**Re: SSD-80287510 – Residential development with infill affordable housing,
84 Tallawong Road, Rouse Hill**

Attachment 1

Blacktown Council's submission to SSD-80287510 – Residential development with infill affordable housing, 84 Tallawong Road, Rouse Hill

1. Waste Management Section

Figure 22 – Plan of Basement 03.

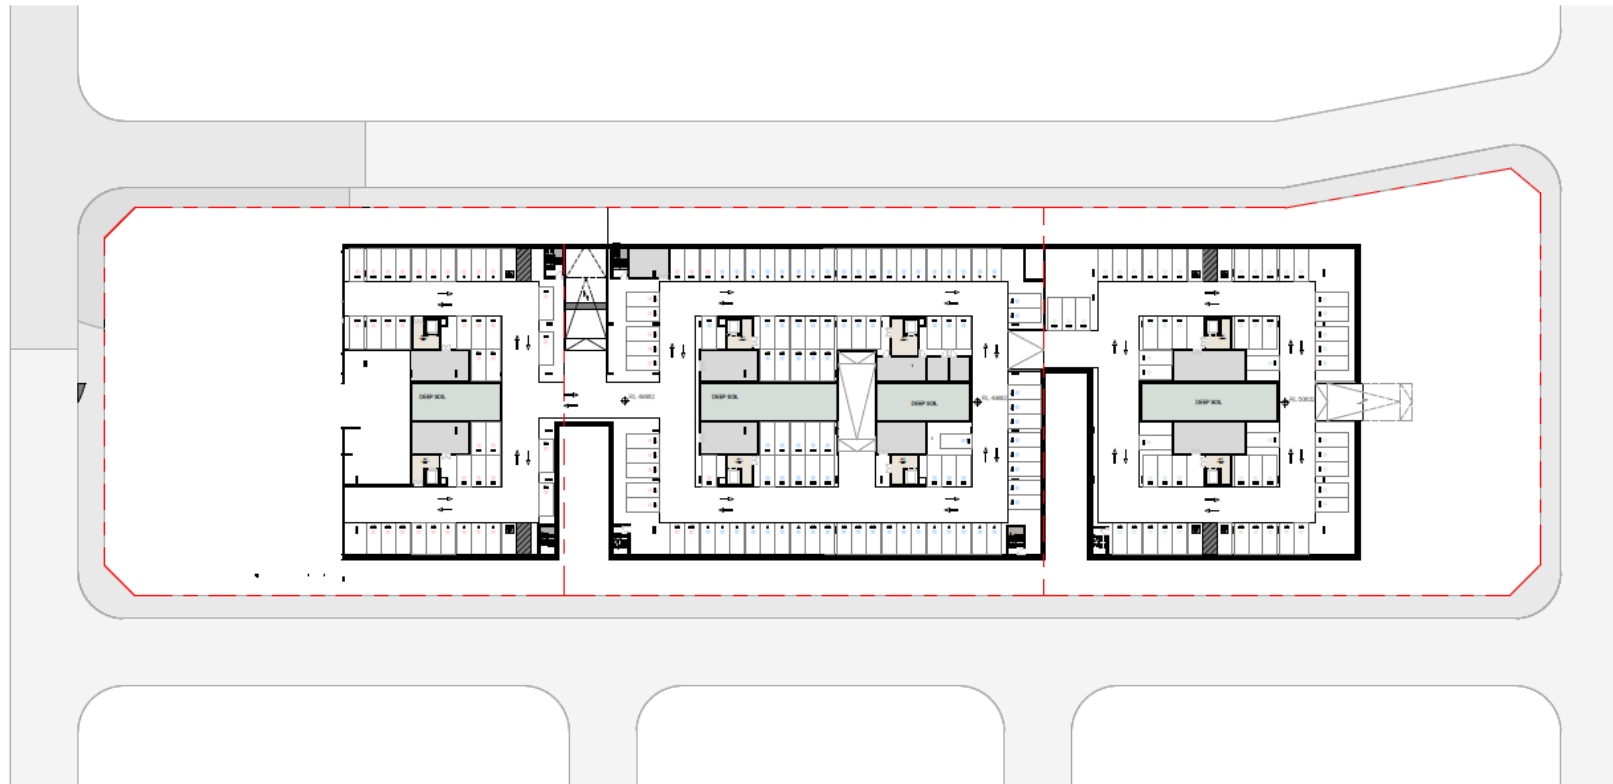
- a) Confirm if the basements are combined for Buildings A and B, C and D, and E and F. This is not clear from the plans or from the waste management plan. Please update the latter with this information.

- r) Indicate on amended plans, the chute discharge and linear track system on the basement plans. Currently, only a box labelled 'chute discharge' is indicated.

- t) Differentiate on amended plans, the 1,100L waste bins, 240L recycling bins and 240L FOGO bins. Currently all the bins look the same size, and no FOGO bins are indicated despite FOGO being referenced in the waste management plan.
- u) Indicate on amended plans, the bin tug and trolley storage area. It must be caged and secured and located adjacent to the loading bay.
- v) Provide the swept paths showing operation of the bin tug and trolley at each of the chute discharge locations and around the main waste room and loading bay area.
- w) Provide for the waste and recycling generation rates listed in the EPA's *Better Practice Guide for resource recovery in residential developments 2019* for each proposed retail/commercial tenancy.
- x) Demonstrate on amended plans, that ramp grades and changes of rate of grade on the ramp do not exceed 15.4% (as per AS2890.2 Tables 3.2 and 3.3).
